**Consultation Response from KC,  
 Trees**
**2020/90110 16, Greenroyd Croft, Birkby, Huddersfield, HD2 2DQ**
**Alterations to existing decking and replacement planting**
**Date Responded: 10/02/20**
**Responding Officer: Nick  
 Goddard**
**Responding Ref: TPO 02/79**

REVISIONS C - Extent of Decking reduced further and trees shown along boundary following consultation with planning officer	
PROJECT 16 Greenroyd Croft	
DRAWING NUMBER 16-0002	SCALE 1:200 @ A3
DRAWING Section Elevation	REV C

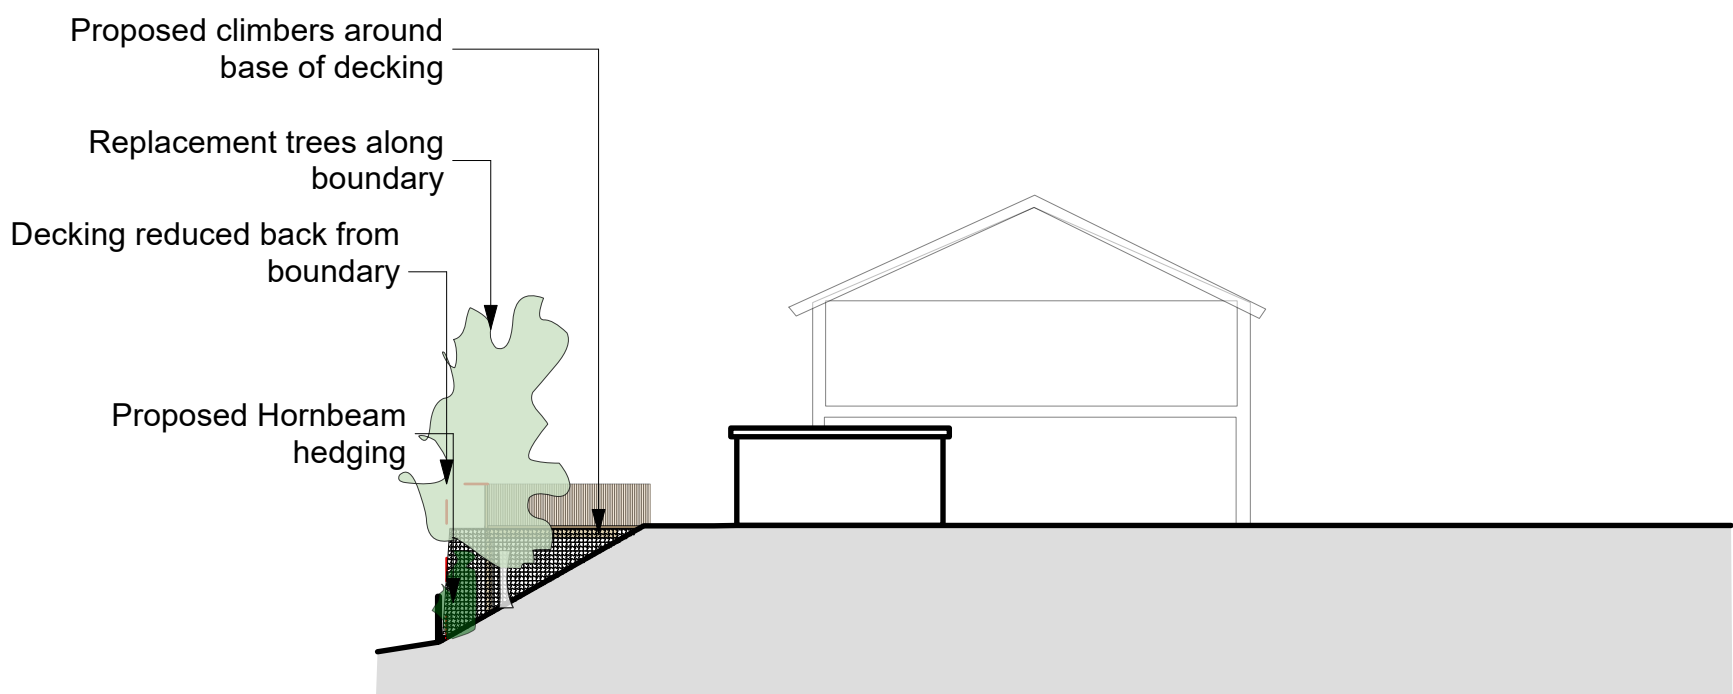
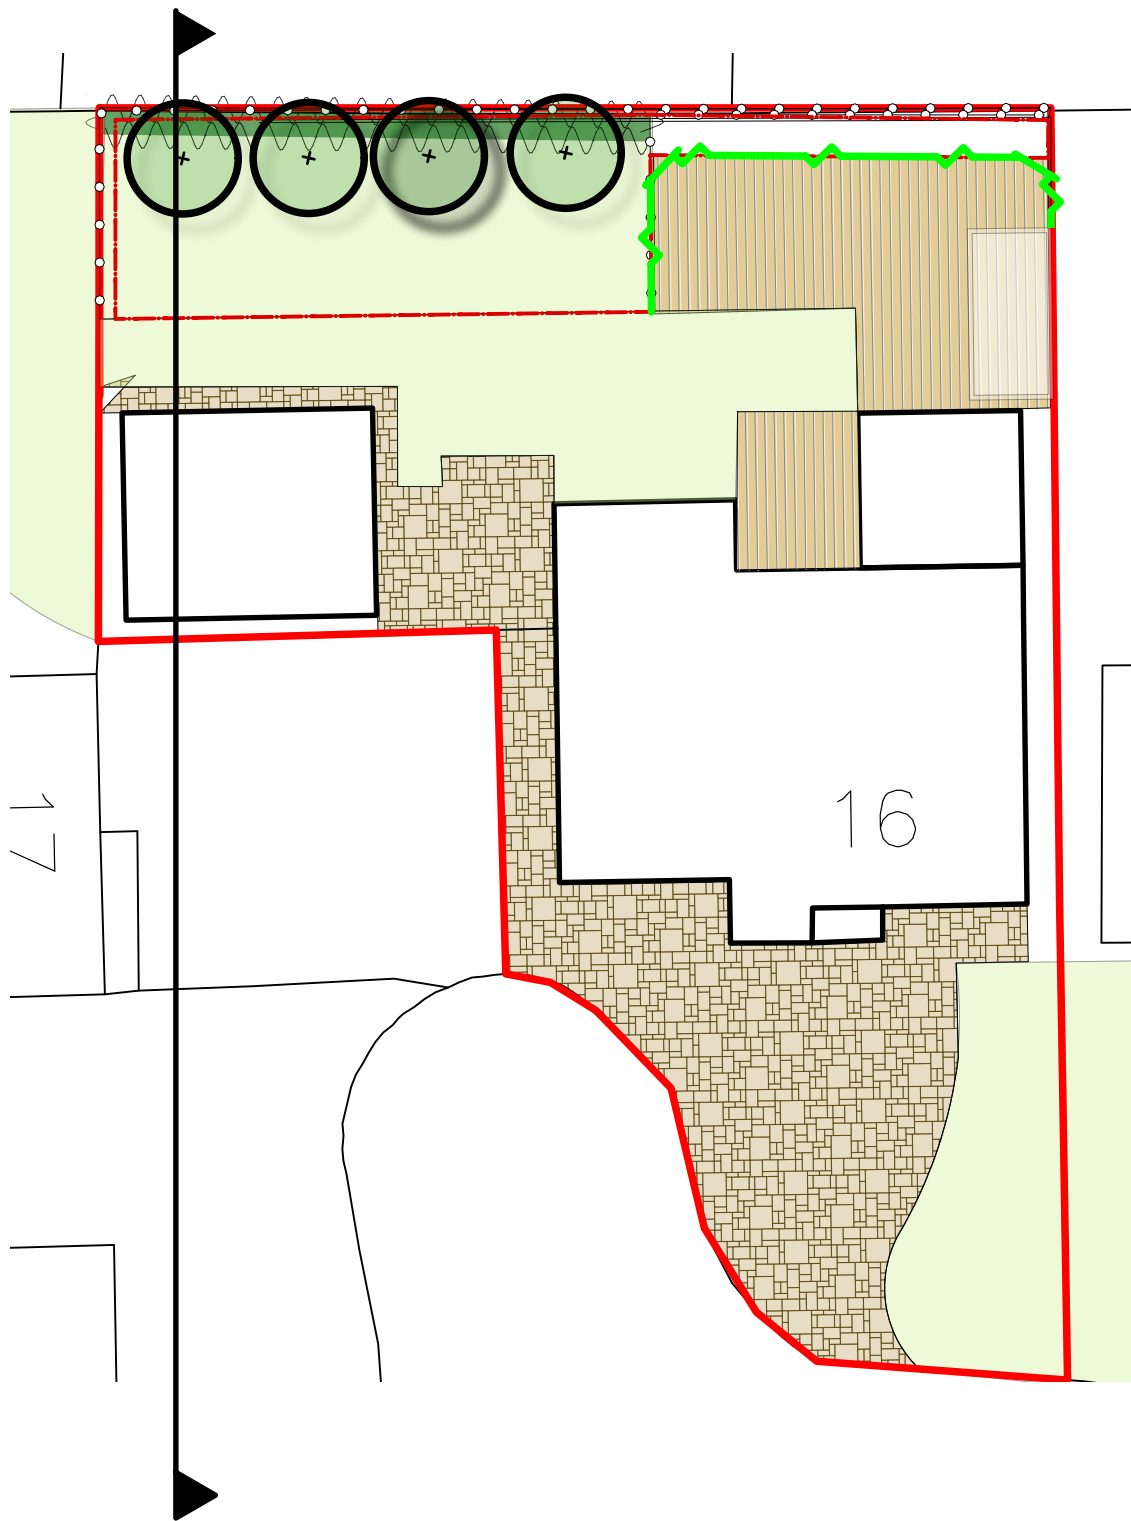
The difference between this and the previous application is not significant with regards to the space afforded for the replacement trees. As I stated in my previous comments;

*“The required replacements are to be 1.5-2m in height, 2 Oak and 2 Rowan. These trees when planted in the location shown on the submitted drawing will be 1m from a 4m high barrier to light. This will effectively prevent the growth and establishment of these trees in their first years.*

*If the trees do survive and have developed a crown, which is unlikely, they will be 1m from a fence at 4m high and therefore their developing crown structure will be in constant conflict with the proposed decking and fence.”*

This will still be the case with the proposed scheme under this application. The proposals will therefore effectively prevent the replacement of felled protected trees which would reduce the tree cover in the area and be contrary to policy LP33.
